From: Amanda Scholes on behalf of Planning.Responses
Sent: 01 June 2018 09:05
To: Planning Scanning
Subject: FW: Planning Consultation on LU/120/18/DOC

APPLICATION LU/120/18/DOC
NO:

Registered: 15-MAY-18
Site Address: Directors Cottage Toddington Lane Littlehampton BN17 7PP

Description of Works: Approval of details reserved by condition imposed under LU/249/17/PL relating to conditions 3-Construction Management Plan, 5-visibility splays, 15- landscape scheme & 16-schedule of materials & finishes.

APPENDIX 1 - SITE PLANS - NOT TO SCALE

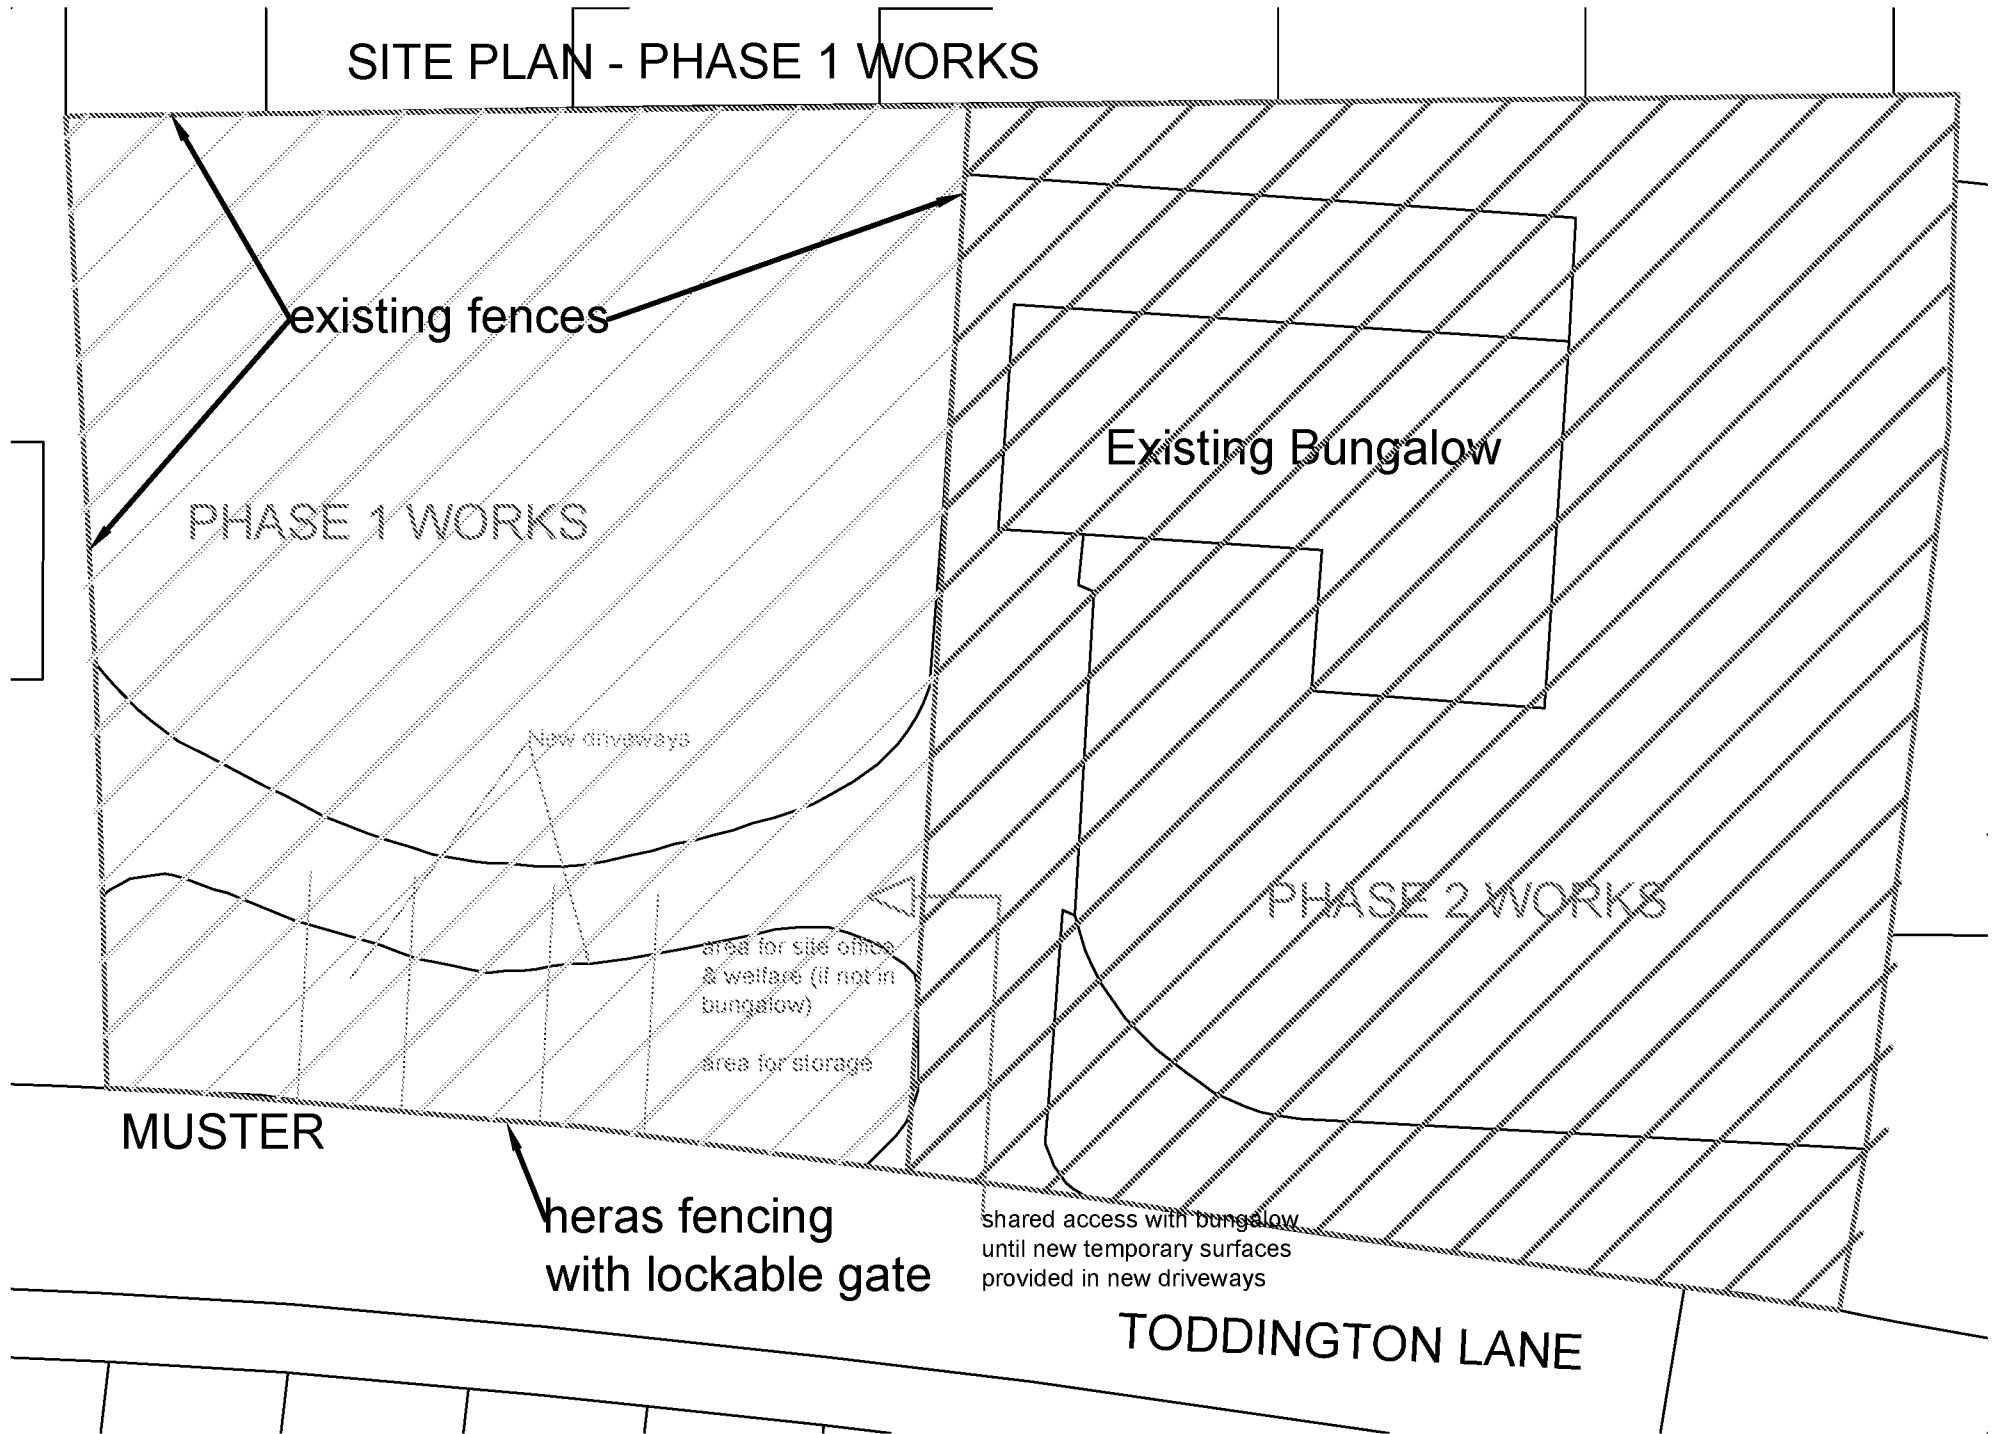
Environmental Health: Agree to discharge Condition 3 in respect of Construction Management Plan referenced as Caldotec Ltd., Construction Environmental Management Plan, Director's Cottage, April 2018. Nevertheless, the close proximity of residential units particularly north and east of the proposed development requires careful consideration in order to prevent detriment to the amenity. On site brick crushing to be avoided and the location of site traffic, storage and the site office to be as far as possible away from existing residential units.
